**Ute Pass Mini Warehouse
 Transportation Memorandum
 (LSC #184110)
 February 2, 2018**

Add PCD File No.
 PPR 18-028

RE: Ute Pass Mini Warehouse
El Paso County, CO
Transportation Memorandum
LSC #184110

1 SITE PLAN
SCALE: 1"=30'-0"

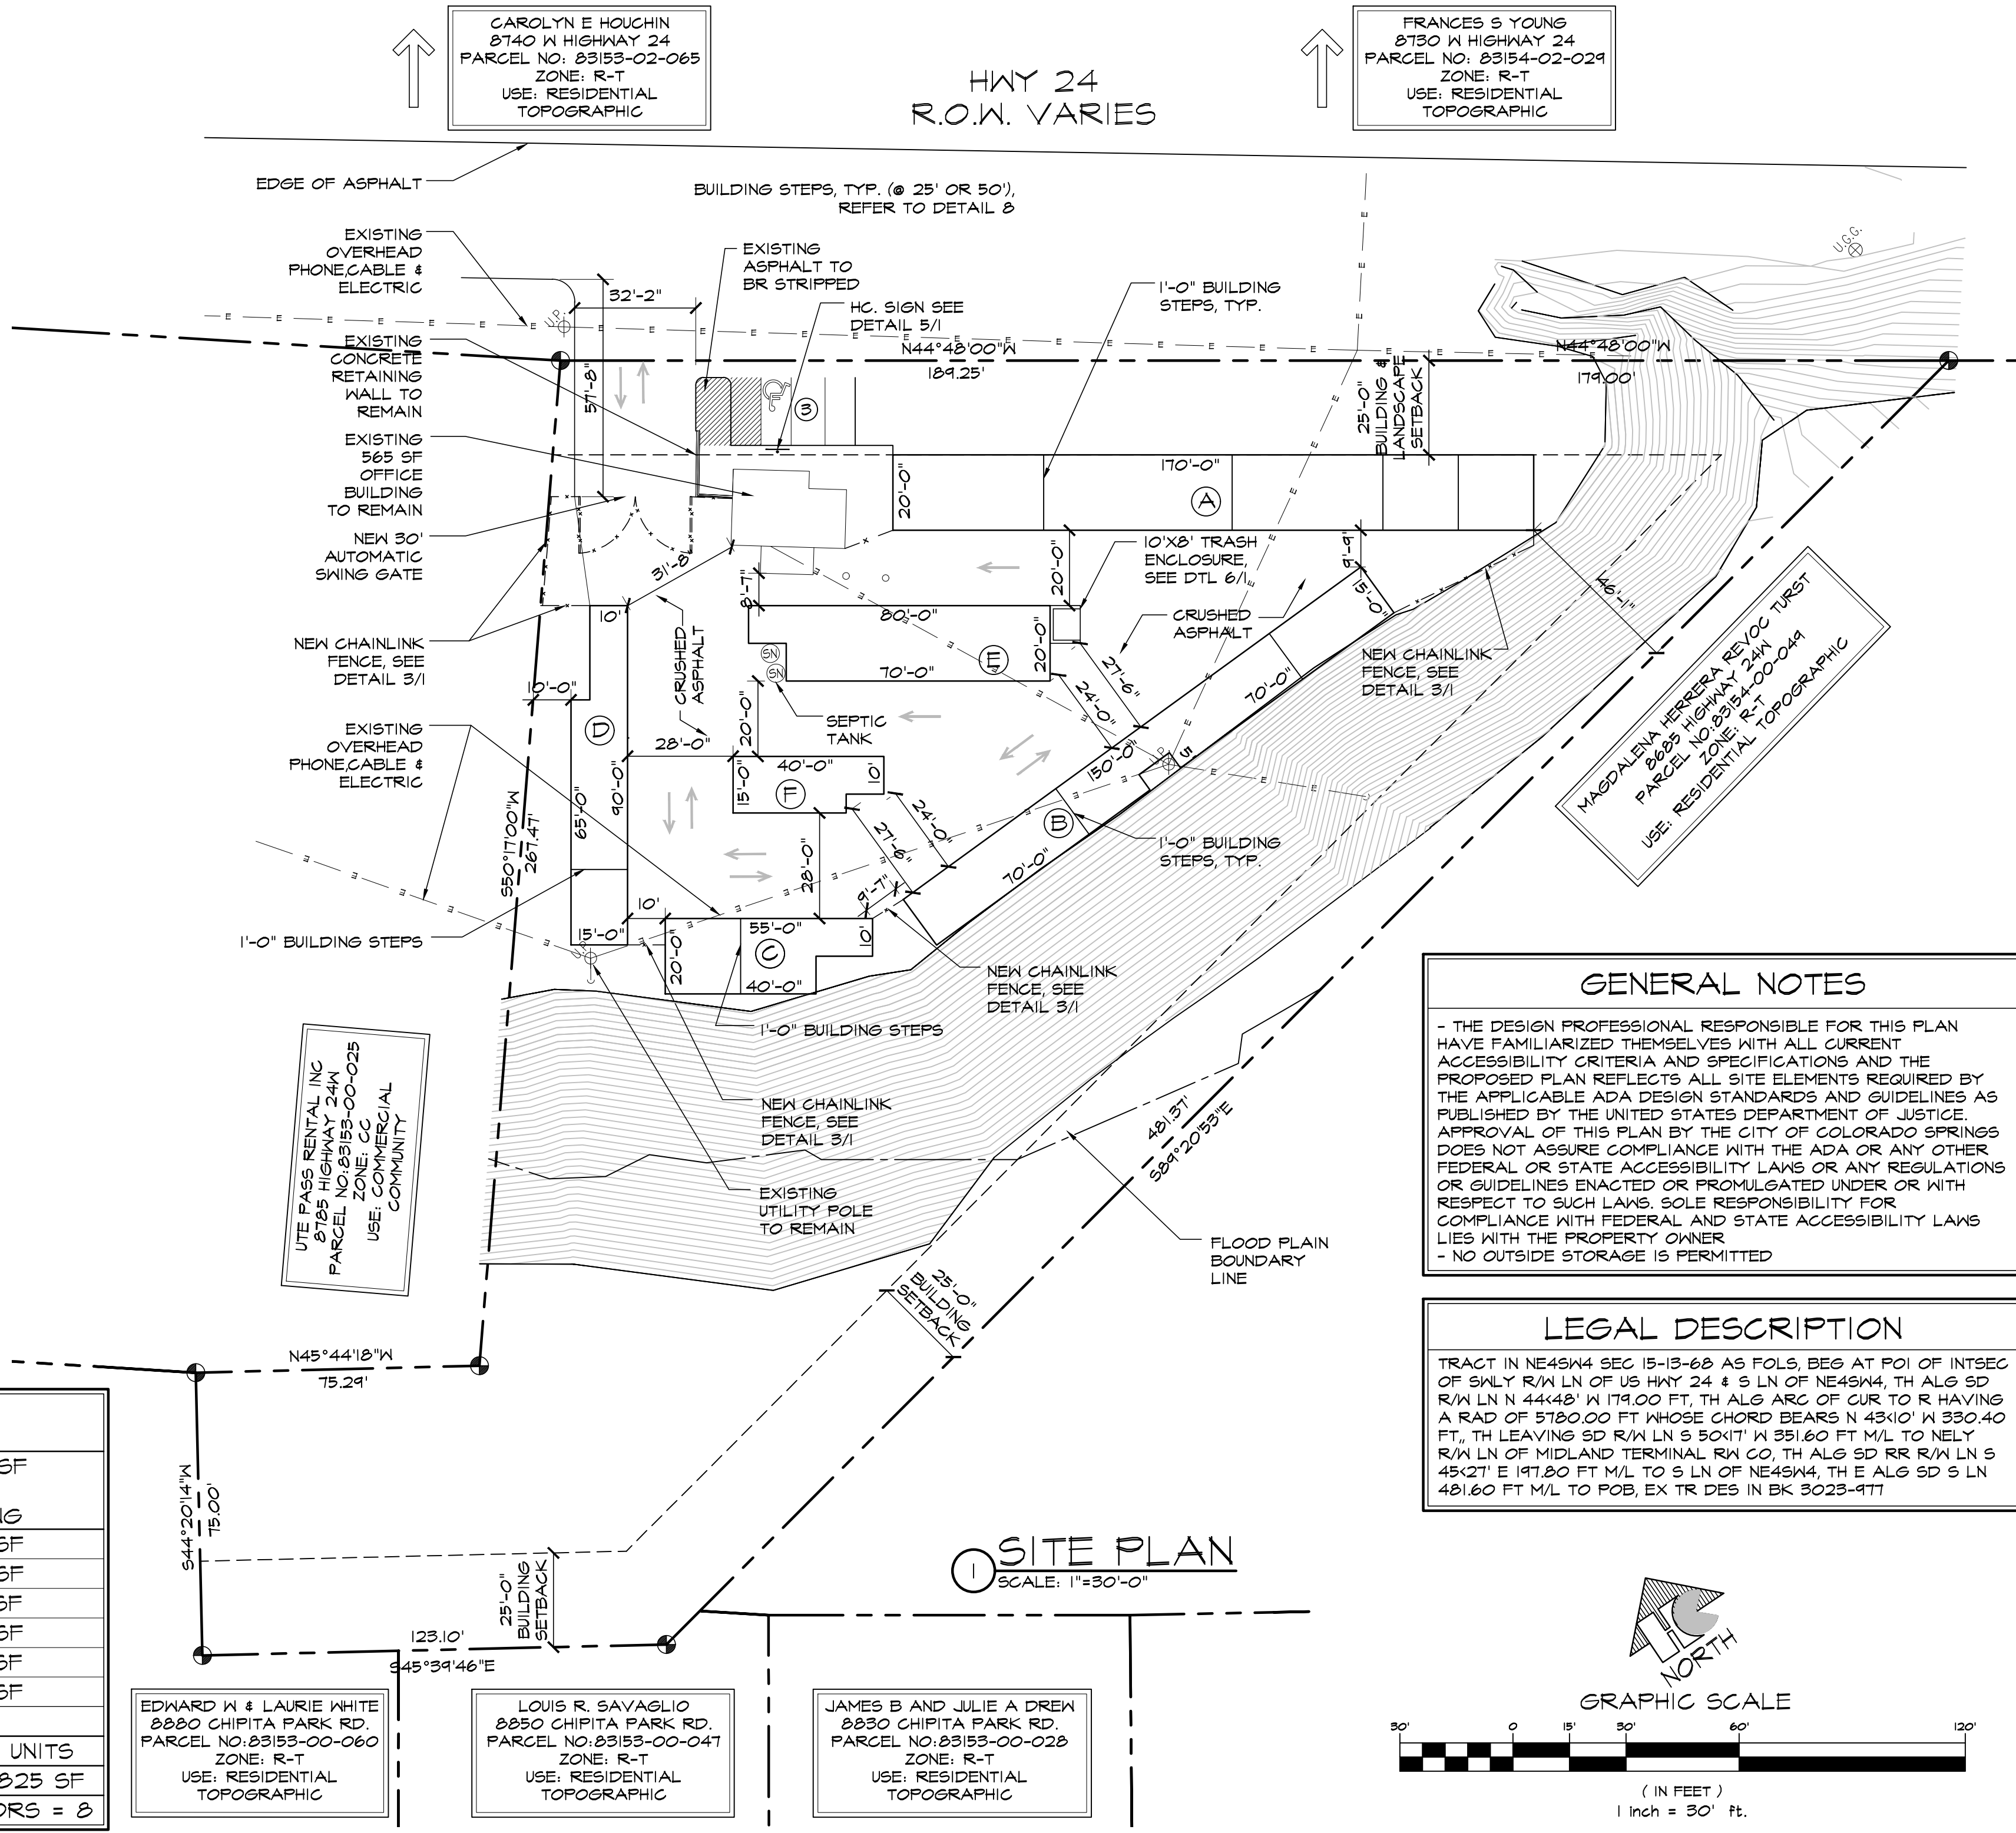
there is curb and gutter in this section of Hwy 24 with distinct access points. this report should describe them, as well discuss the opening at the east end and how you intend to prevent or allow traffic to enter/exit at that location.

Please define your use of the term "mini frontage road"
